Planning Application Ref: **AW/156/19/T**

Location: **Royal Bay Nursing Home, 86 Barrack Lane, Aldwick, PO21 4DG**

Description of works: **Crown lift by 7m to 1no. white poplar tree and crown reduction by 3m to 1no. London plane tree**

Ref 1

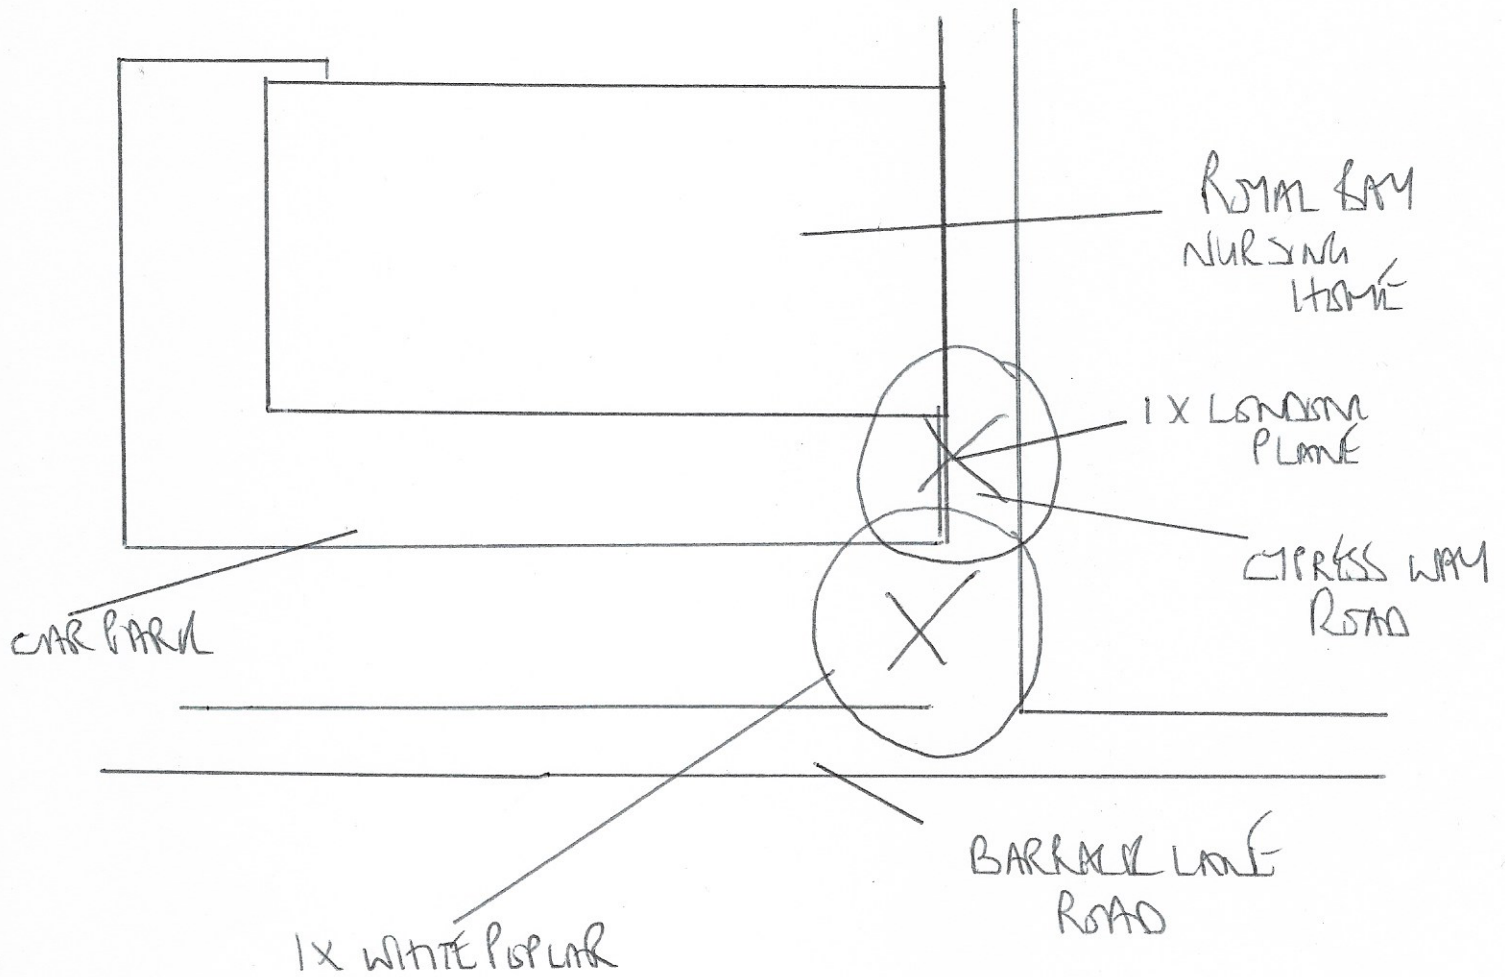
- T1 – Appears to be outwardly healthy and stable with a relatively unmodified and attractive crown profile. It is highly visible to residents and from neighbouring properties, and presently in part from the public highway (footway and carriageway) – although I expect it to become highly visible from there too long before it reaches over-maturity. It is a fine example of its type with adequate room to grow-on in harmony with its surroundings.

- Branches grow low over the driveway and garden areas and may impede the passage of high-sided (delivery) vehicles to the main building.
- T2 - The subject tree has been incorrectly identified as a white poplar, although it is clear from site inspection that the hybrid black poplar is not so dissimilar, dominates the position marked on the applicant's plan and is the only obvious candidate for the work proposed. It appears to be outwardly healthy and stable with a relatively unmodified and attractive crown profile. It is highly visible to residents, from neighbouring properties and the public highway (footway and carriageway). It is a landmark tree and fine example of its type.

- Overhead canopy clearance appears adequate although it can be assumed the applicant is concerned for impede of high-sided (delivery) vehicles accessing the main building and using the public carriageway.

- T1 - There is no obvious arboricultural justification for the work proposed. Crown reduction work would irrevocably spoil its natural looking form and remove its potential to provide a high visual amenity.
- T2 – The tree will tolerate a crown lift to the proposed extent without undue harm to its ongoing health and vitality. This element of the application is acceptable.

- As it stands, I recommend **REFUSAL** for this application.

- I would like to see the applicant submit an amended work specification for T1 such as detailed below, which would seem to address their concerns whilst preventing a diminution of the tree's landscape and public amenity value:
 - Crown lift to provide a maximum of 3m overhead clearance on all aspects, to a maximum of 5m directly over the driveway.

Reason: To permit reasonable use and enjoyment of garden area, and allow unobstructed access for high-sided vehicles to main building.
